Your Ref: OWPC20600
Our Ref: EP/138/18/HH 06-09-2018
Please ask for:
Andrew Wood

Construction of garage to west elevation (amendment to previous approval
EP/159/16/HH)

Tamarisk House 5 Tamarisk Way East Preston

Side Elevation (west)

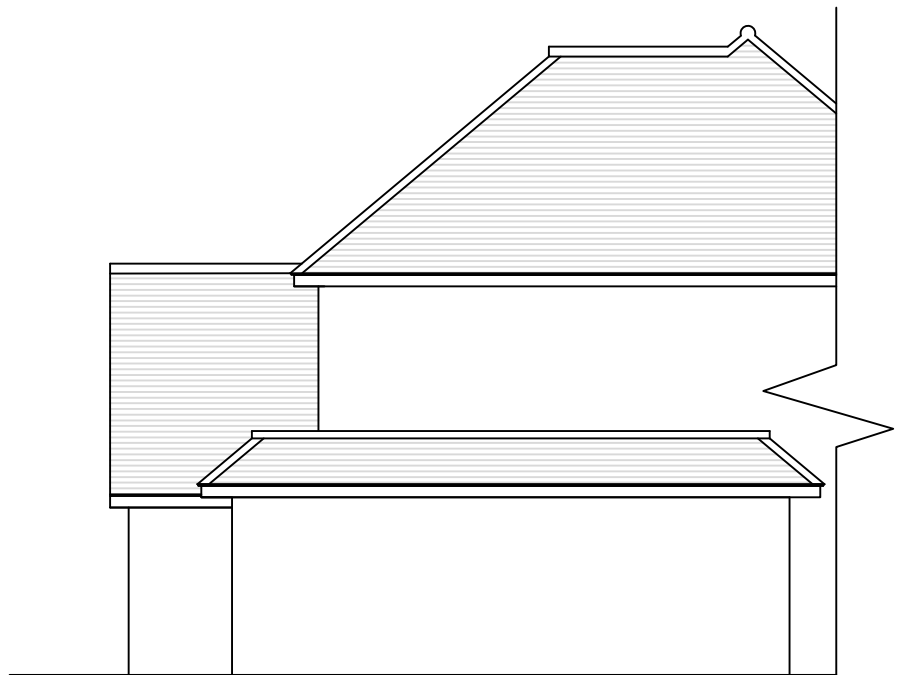
- c) the side elevation to the West (unlike to the East) shows only a partial elevation so again it is difficult to see the overall impact*
- 3. I believe there is a hedge within falling distance of the proposed garage.*

Ground Floor Plan (1:100)

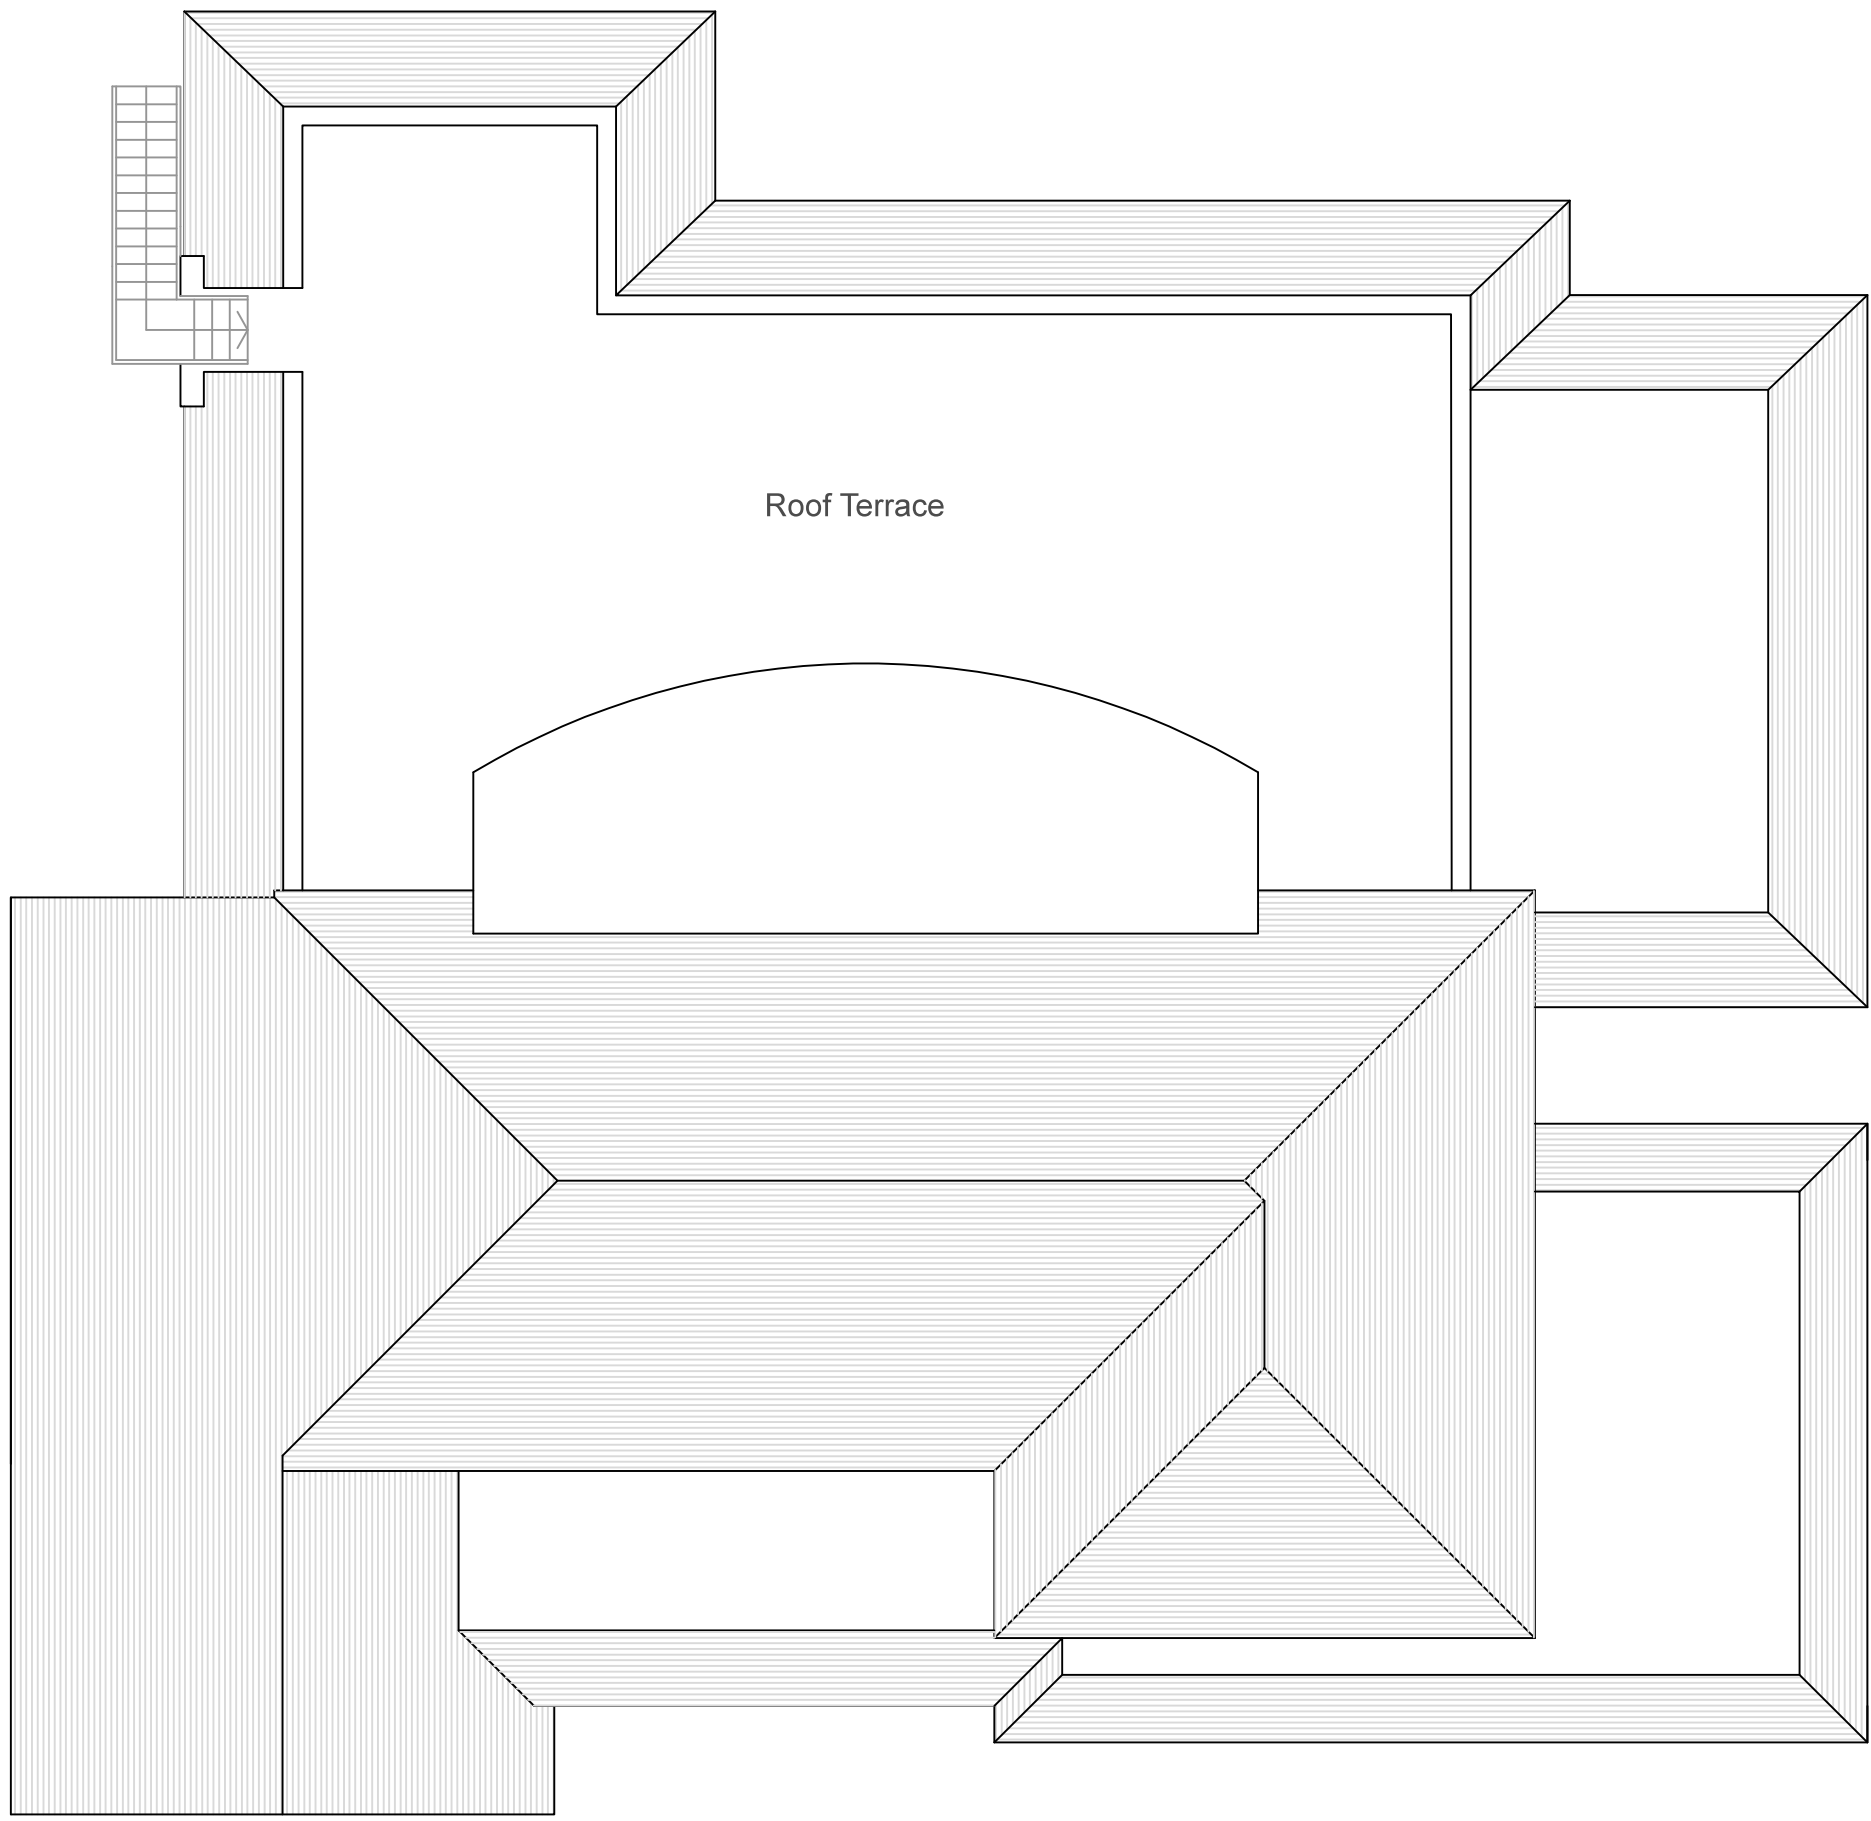
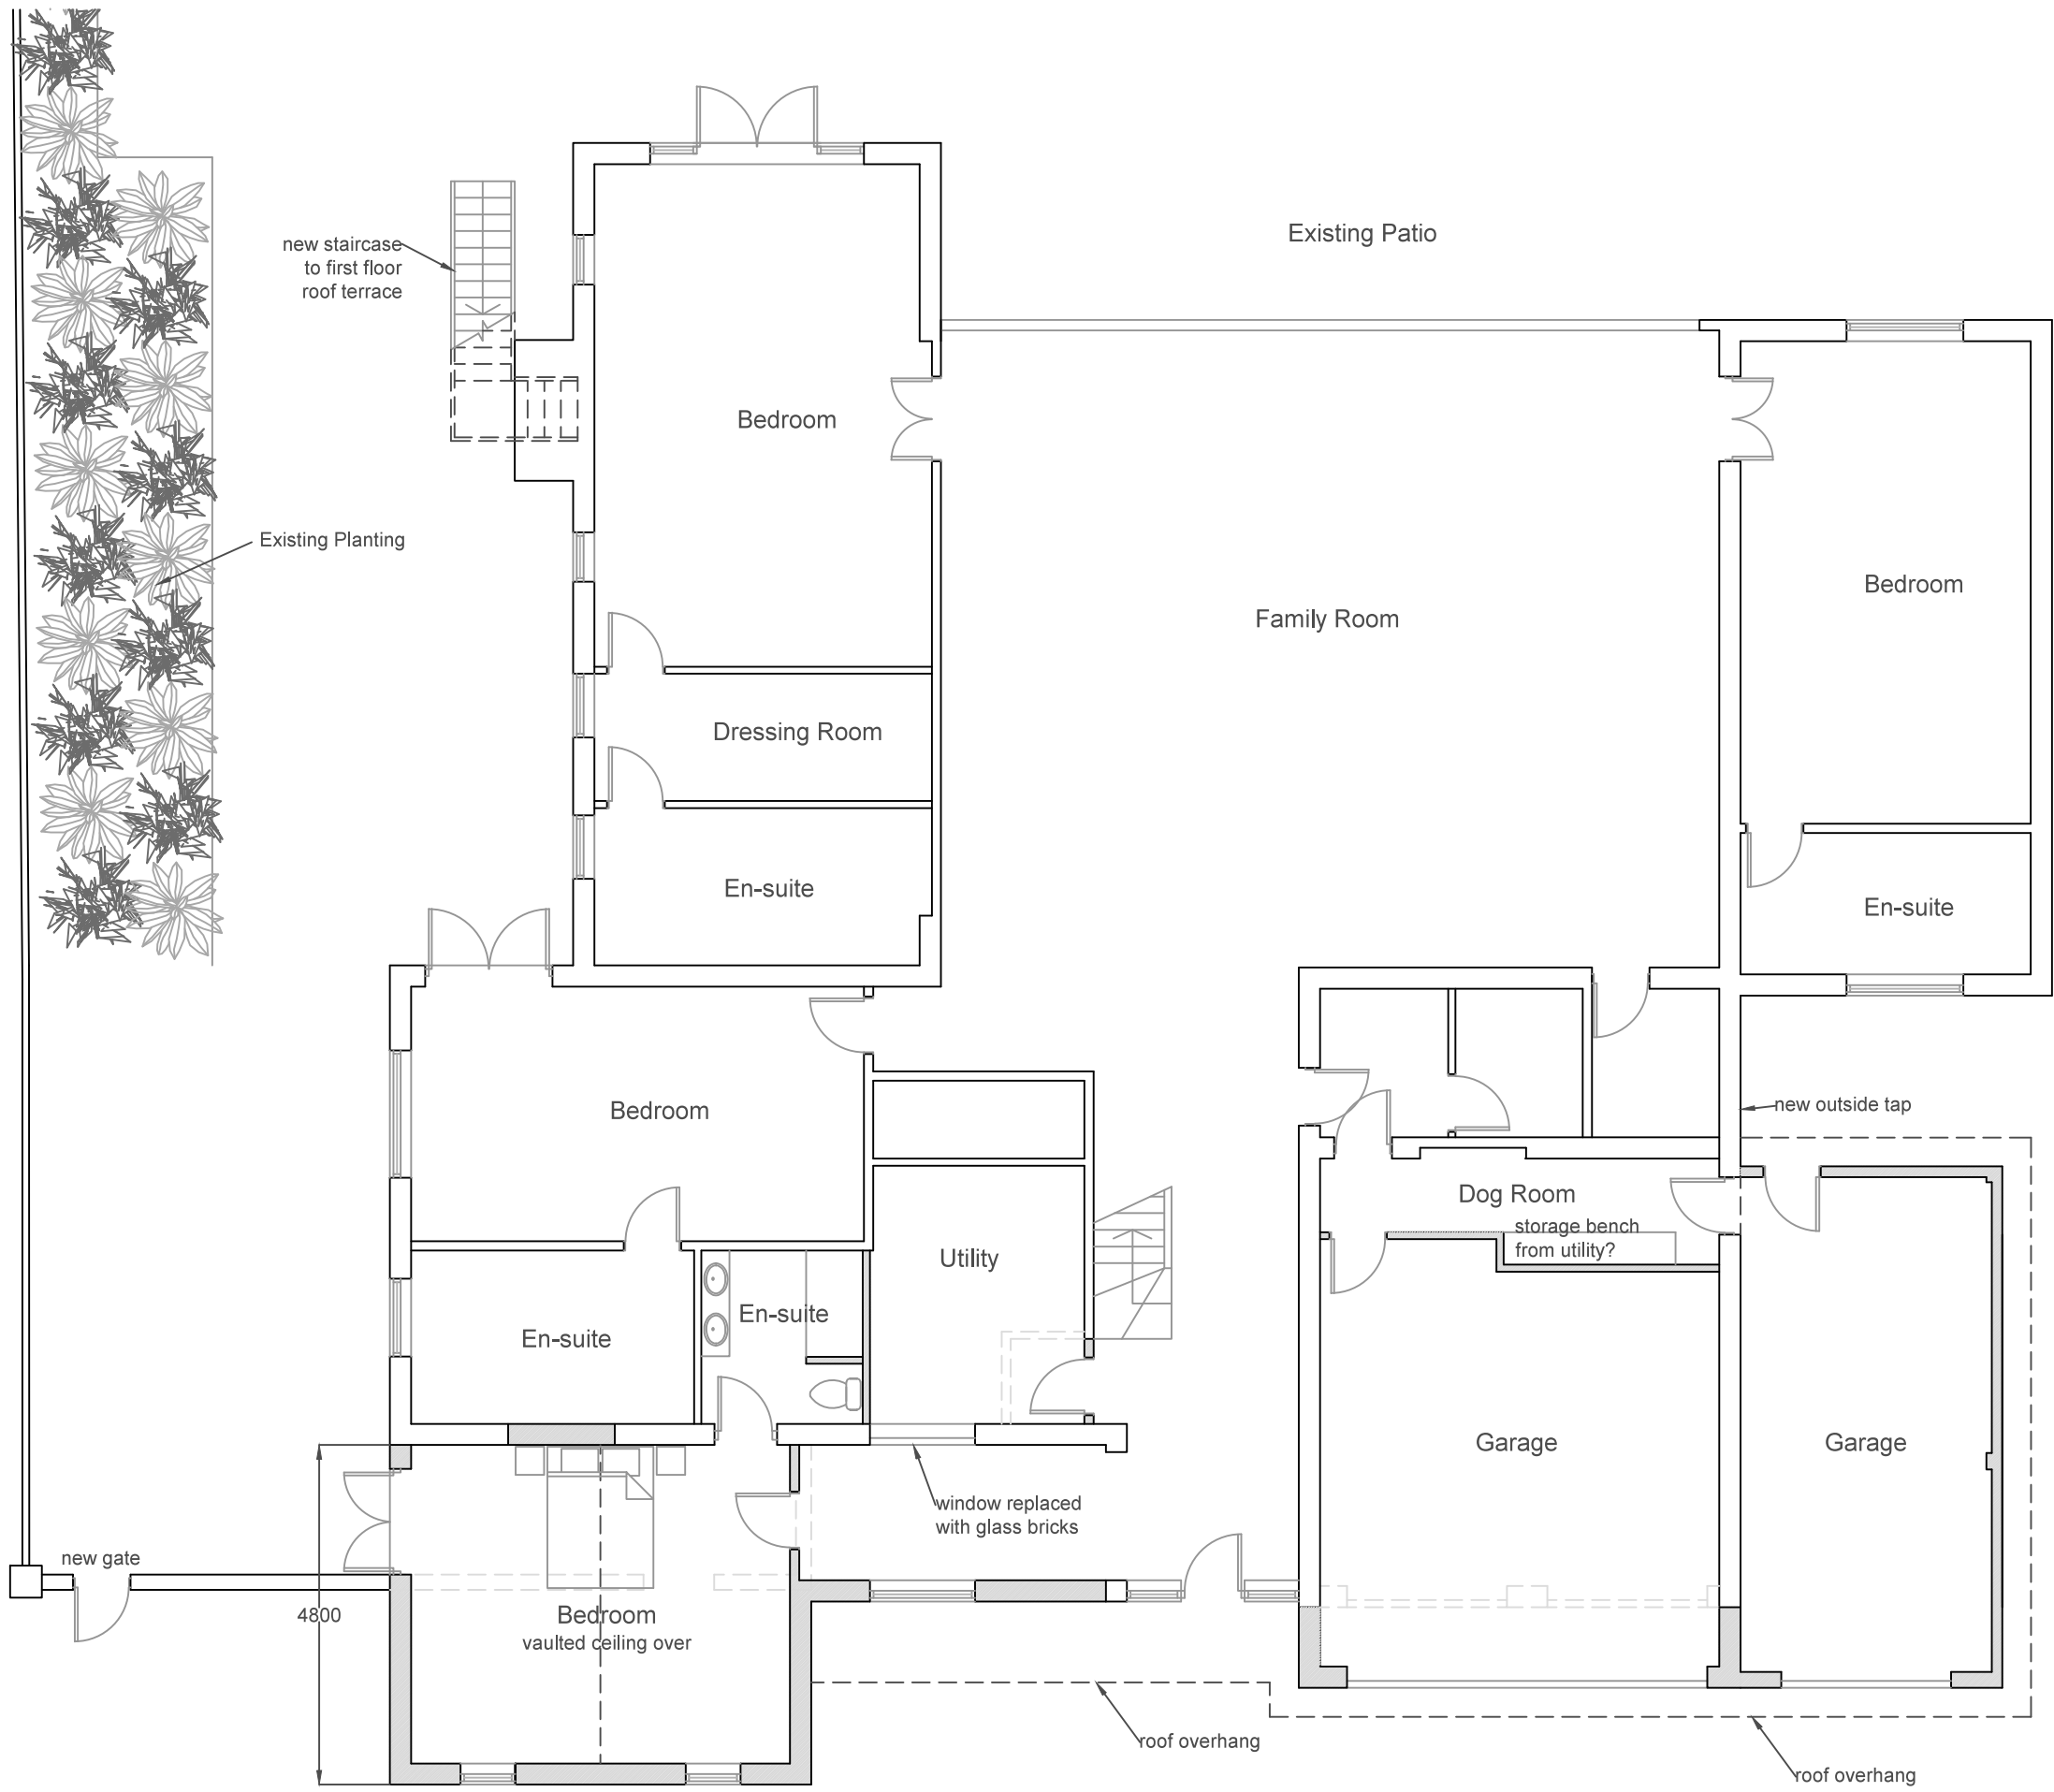
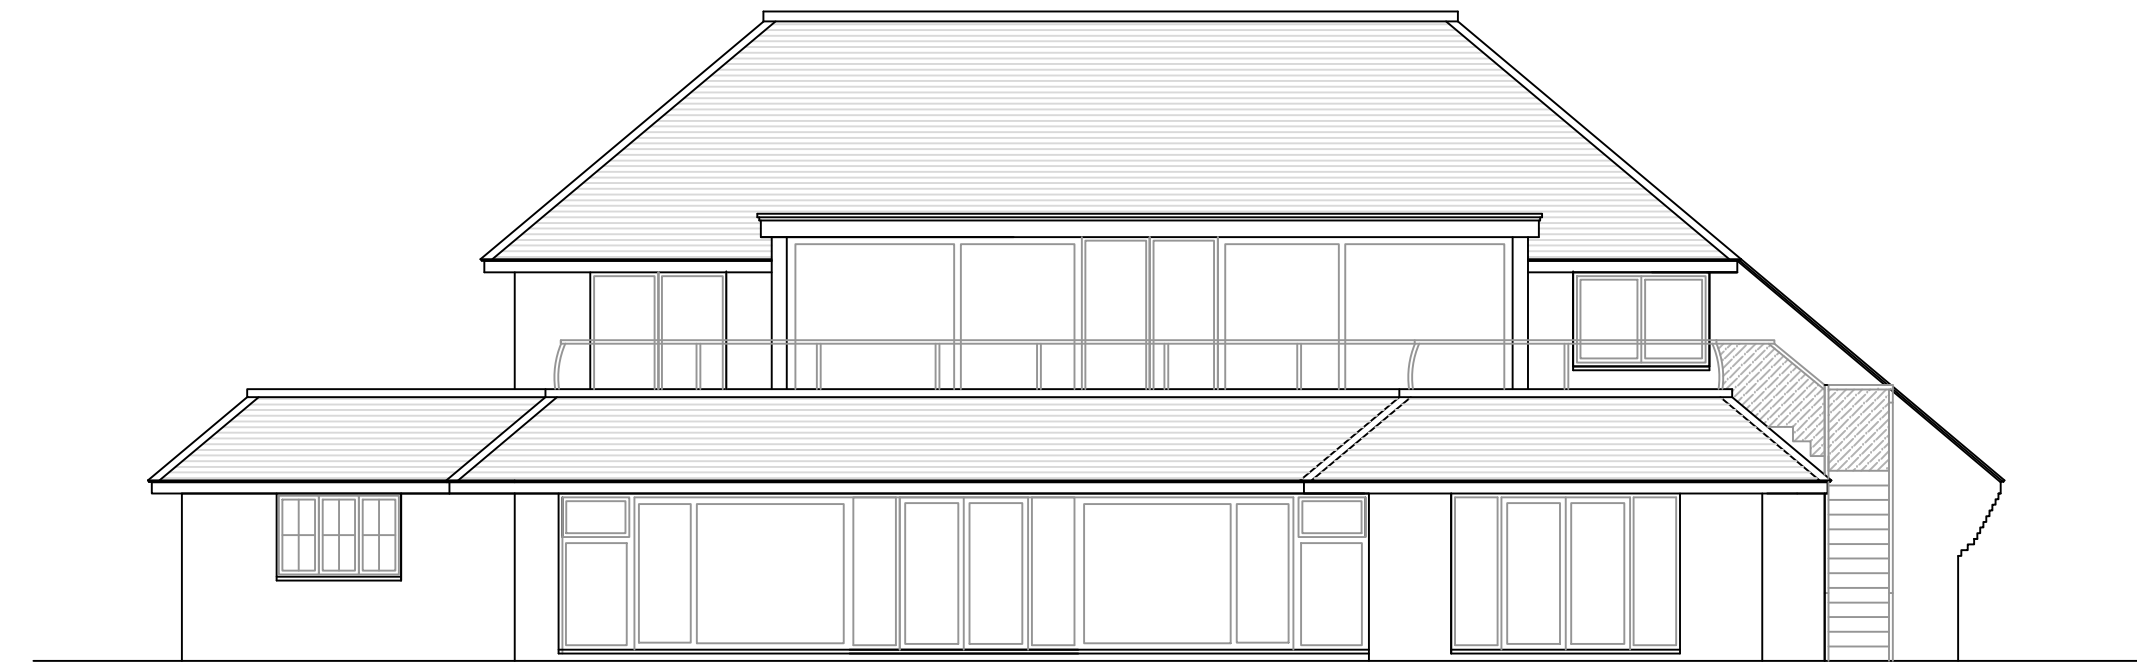
a) The distance to which the proposed new garage will extend to the West varies according to which plan is looked at. The roof plan shows it extends to the West the same as the previous extension (South West bedroom and ensuite) whereas the ground floor plan and the North view show it extends slightly less.

b) the ground floor plans show the Eastern boundary but not the Western one which makes it impossible to assess the impact of the new garage on our property
